## Department of Primary Industries

**West Culburra Mixed Use Concept Plan (MP 09\_0088.)  
Response to exhibition of Environmental Assessment**

### West Culburra Mixed Use Concept Plan (MP 09\_0088) Response to exhibition of Environmental Assessment Comment by Fisheries NSW

### **West Culburra Mixed Use Concept Plan (MP 09\_0088) Response to exhibition of Environmental Assessment Comment by NSW Office of Water**

APPROX BILLYS ISLAND
SEPP14 WETLAND EXTENT

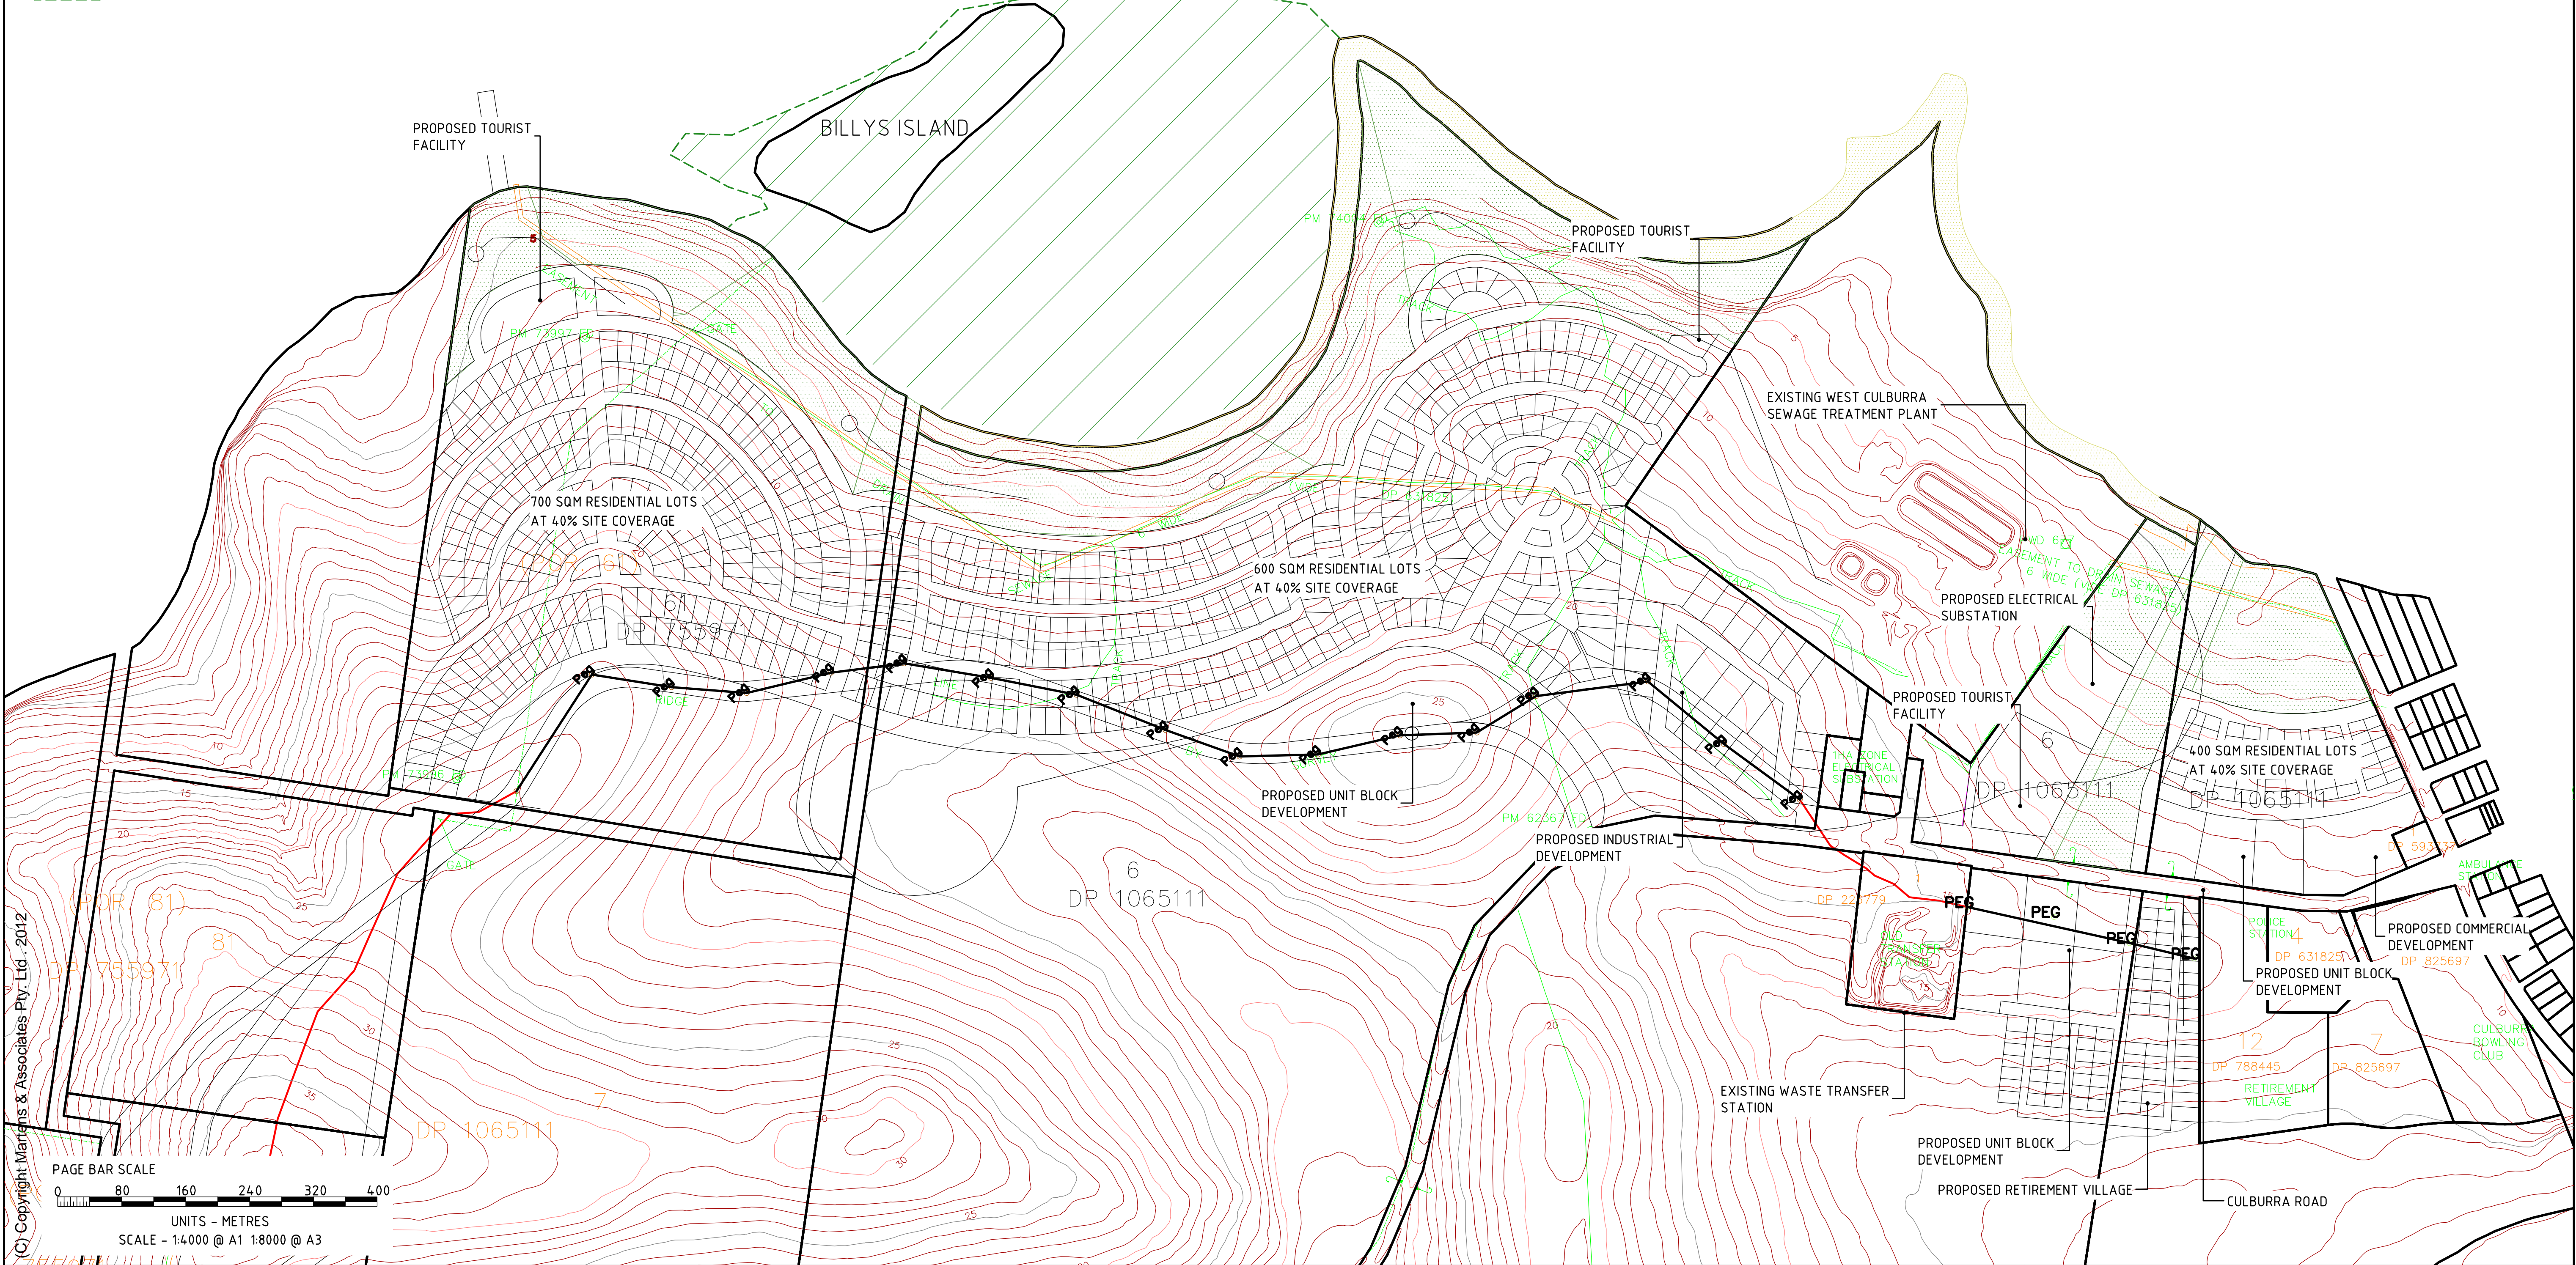
components of the development and subsequently its ability to adequately filter pollutants emanating from the residential subdivision is highly questionable. The Sediment and Erosion Control Plan prepared by Martens and Associates (Appendix P) depicts Earth Diversion Bunds and Sediment Basins located within the buffer zone. The description of the Proposal also highlights the intent to construct a pedestrian/bike path through the buffer and construct various other recreational facilities such as BBQ shelters, picnic tables, fitness equipment etc. There is also a clear intent to clear parts of the buffer right down to the shoreline to create "vistas".

Page 79 of Appendix O suggests that all the APZs, stormwater treatment basins and swales are to be located outside the vegetation setback from the Crookhaven River. This is contradicted by the Sediment & Erosion Control Plan (Appendix P) which clearly shows sediment basins and earth diversion bunds within the foreshore buffer. The Sediment & Erosion Control Plan also shows the earth diversion bund crossing proposed streets and passing through housing allotments which underlines the fact that water quality treatments have not been properly designed.

The proposed buffer will be compromised by a range of ancillary uses including clearing of vegetation beyond the shoreline to create water vistas and some asset protection zones, earthen swales and bio-retention ponds for water quality treatment, in addition to more passive uses such as a pedestrian/bike path and picnic tables.

Water quality control structures for example will require permanent access and ongoing maintenance which will continue to compromise the riparian values and intent of the foreshore buffer zone into the future. Such activities should be located outside of the buffer with the exception of providing stabilised flow paths where necessary, for treated discharge to be safely conveyed through the buffer zone and into the Crookhaven estuary.

NOW supports Fisheries NSW advice that the foreshore buffer zone should be redesigned so as to exclude physical structures such as water quality ponds; excluding wholesale clearing for water vistas and bushfire protection etc from within the designated buffer.
